From: Brenda Larsen
Sent: Monday, April 16, 2012 9:16 AM
To: Jeff Watson
Subject: RE: BL-12-00005 Howard

Re: Howard (BL-12-00005)

CRUSE & ASSOCIATES
PROFESSIONAL LAND SURVEYORS
217 East Fourth Street P.O. Box 959
Ellensburg, WA 98926 (509) 962-8242
HOWARD PROPERTY

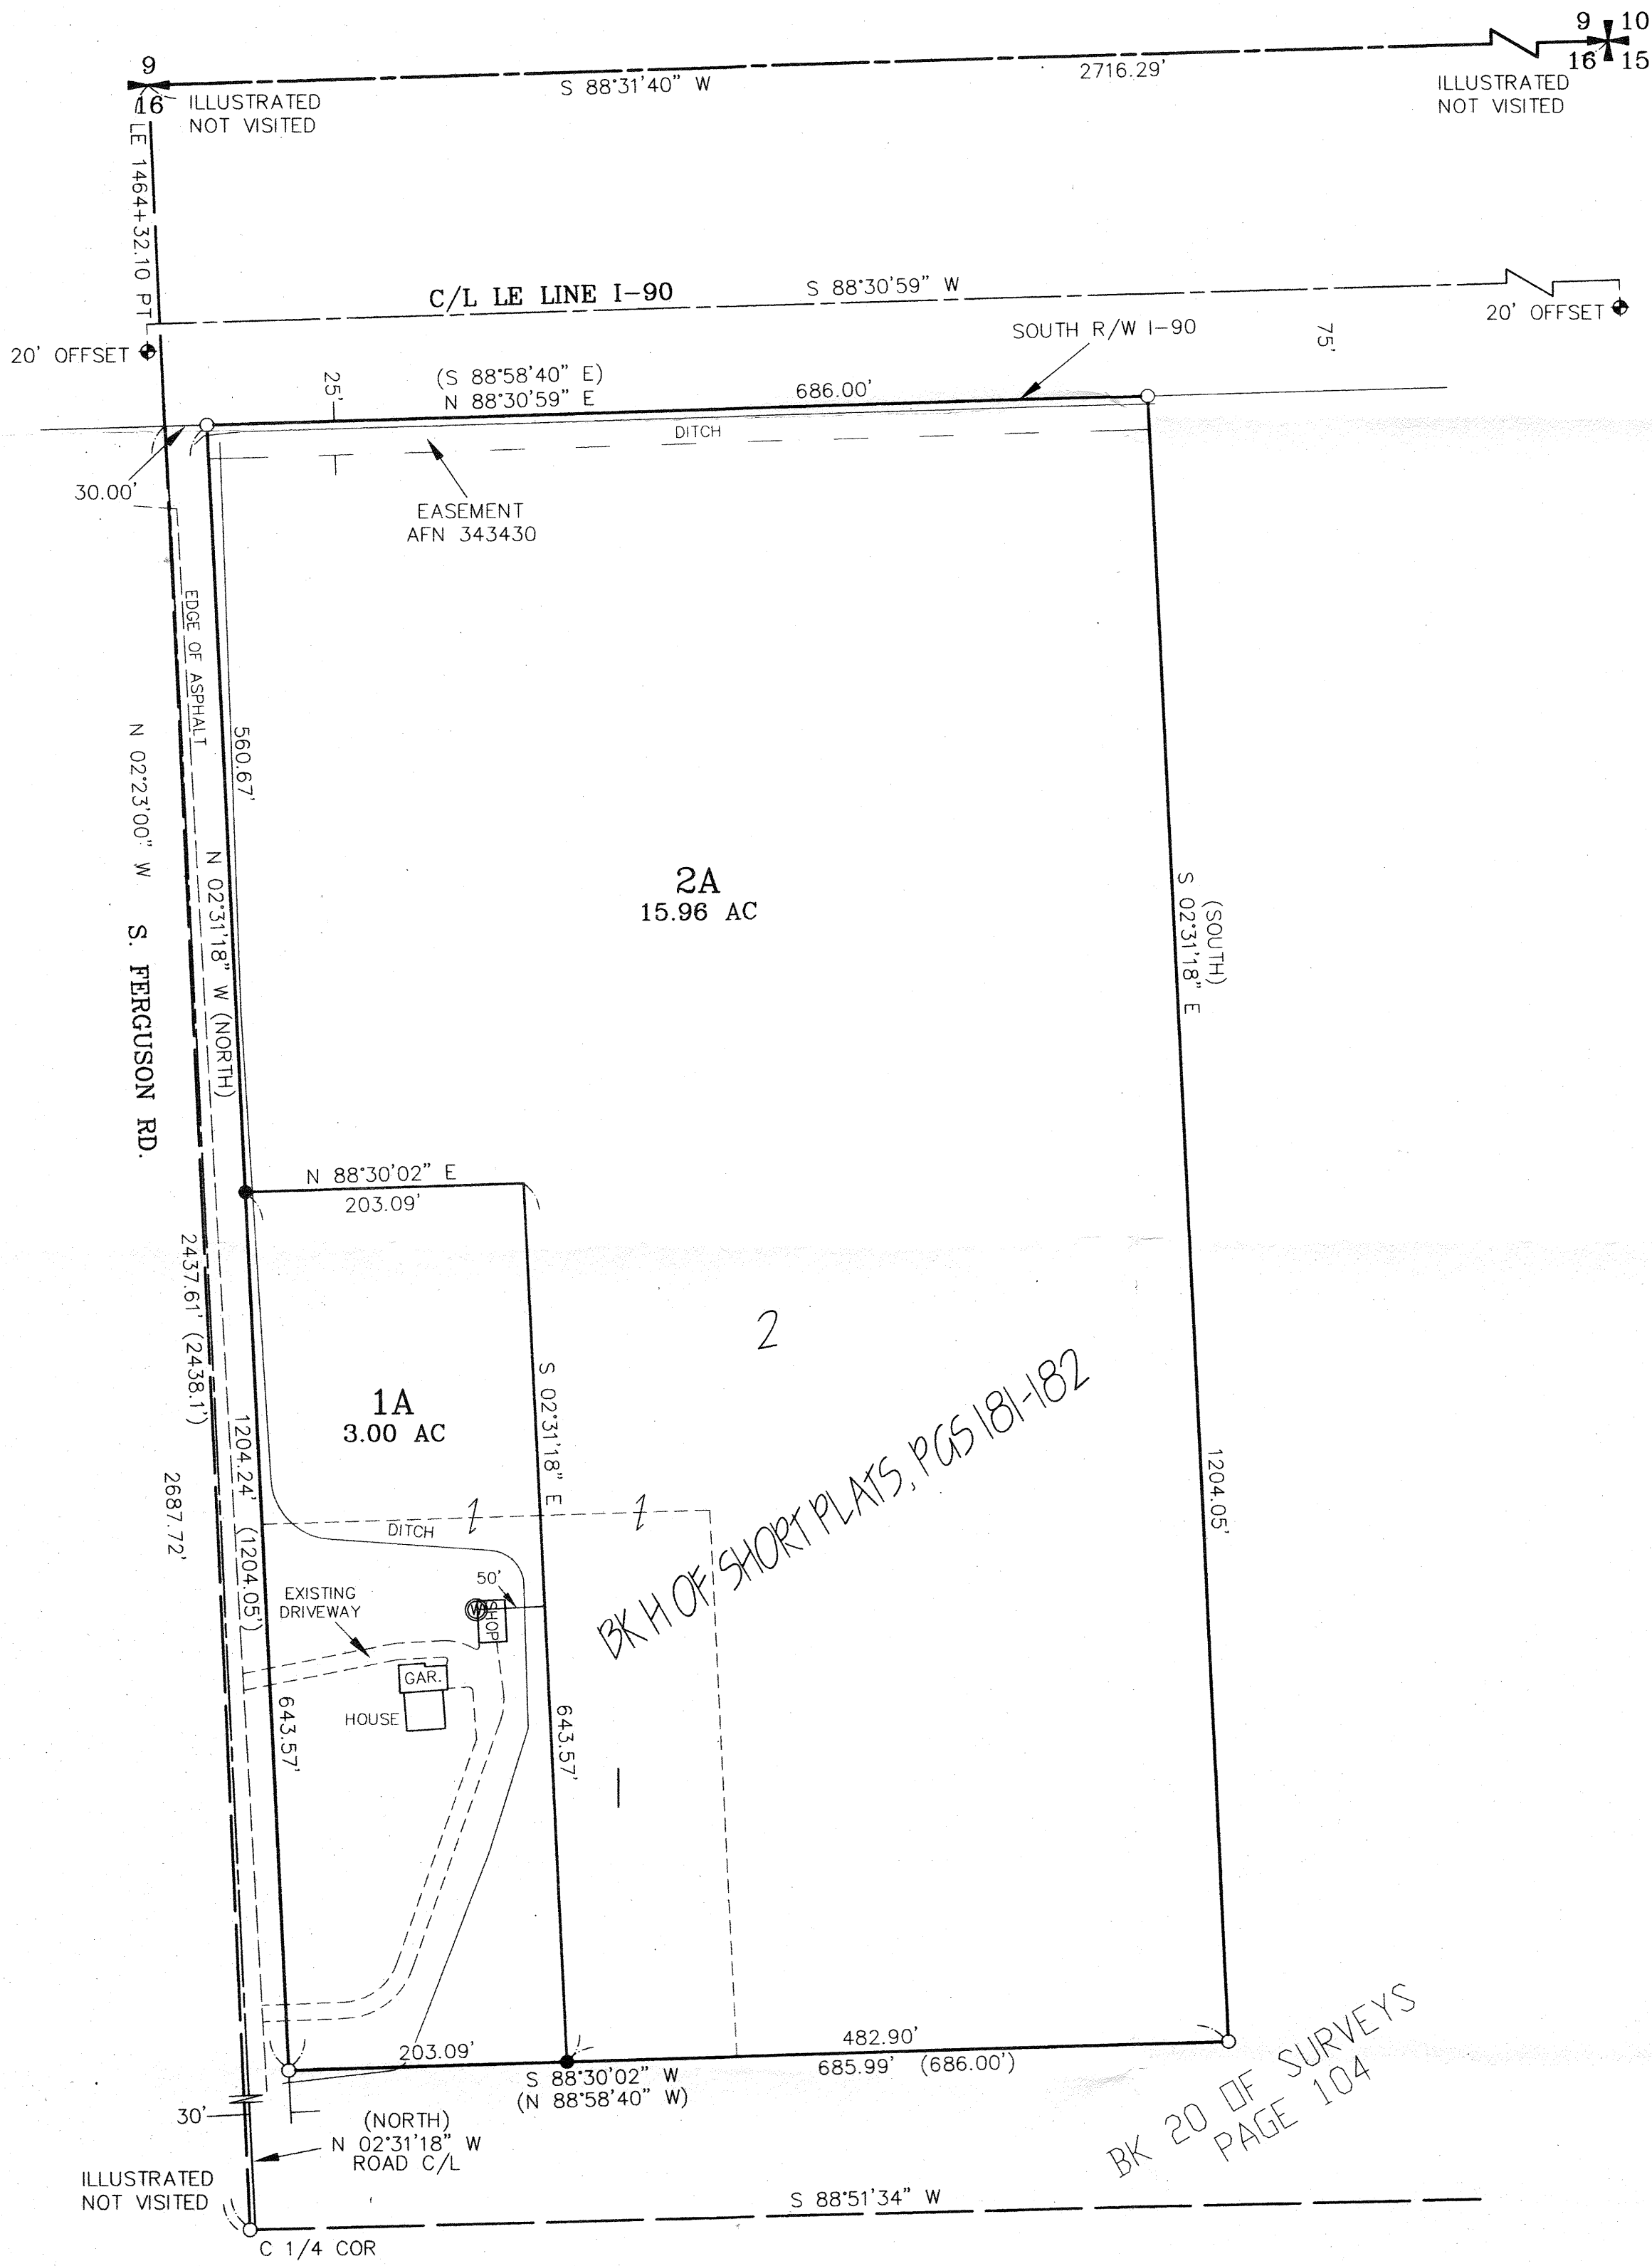
- Ensure that boundary line adjustments do not infringe upon existing structures, to include propane tanks, etc.
- Creation of any additional roads or access must comply with the International Fire Code and KCC Title 12.
- All future development must comply with the International Fire Code.
